**Outline Planning Application, Ribble Valley District
3/11/0776 land at Whiteacre Lane, Barrow, Wiswell**

I refer to my letter of 14 November 2011 concerning the above application and subsequent amended plans provided by the applicant, referenced as BS 11-028/02 Rev C.

Development Proposal - Opt B
(7 No. Residential Dwellings)

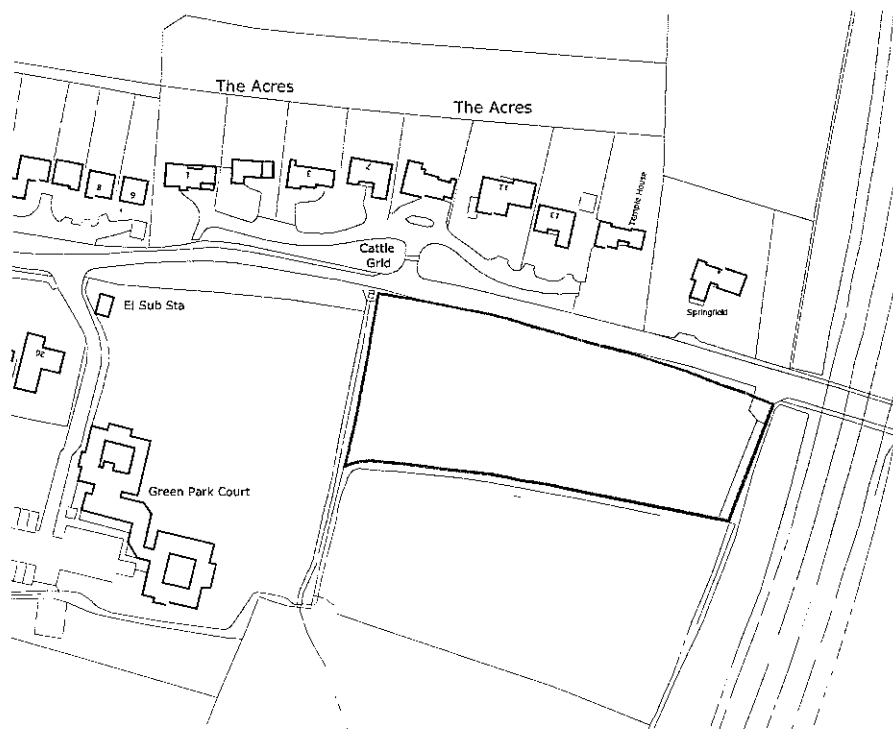
The access to the site has been revised in order to provide a 2.4 metre x 60 metre visibility splay in both directions, consistent with Manual for Streets 2. The design of the access road has also been improved by increasing the width of the carriageway to 5.5m for a minimum of 5m into the site. This will allow an emerging vehicle to be stationary at the junction, while another vehicle can manoeuvre into the site.

The inclusion of the gateway markings at the Speed Limit transition point to the east of the site may not be relevant at this time and an alternative measure may be more appropriate to assist with compliance with the 30mph Speed Limit. This is because it is the intention of Lancashire County Council to introduce a 30mph Speed Limit through Wiswell. The public consultation is presently being prepared and it is hoped to have this completed early in 2012. Therefore, the introduction of the suggested gateway markings would be redundant.

The revised plan does not make any provision for a new footway to the west of the site. While I appreciate that this land does not fall within the applicant's control, there is a potential benefit here that should be considered. To this end, I would be grateful if the status of the land required could be established to ascertain if ownership can be determined.

The precise nature and location of an appropriate speed reducing feature could be agreed as one of the subsequent Reserved Matters.
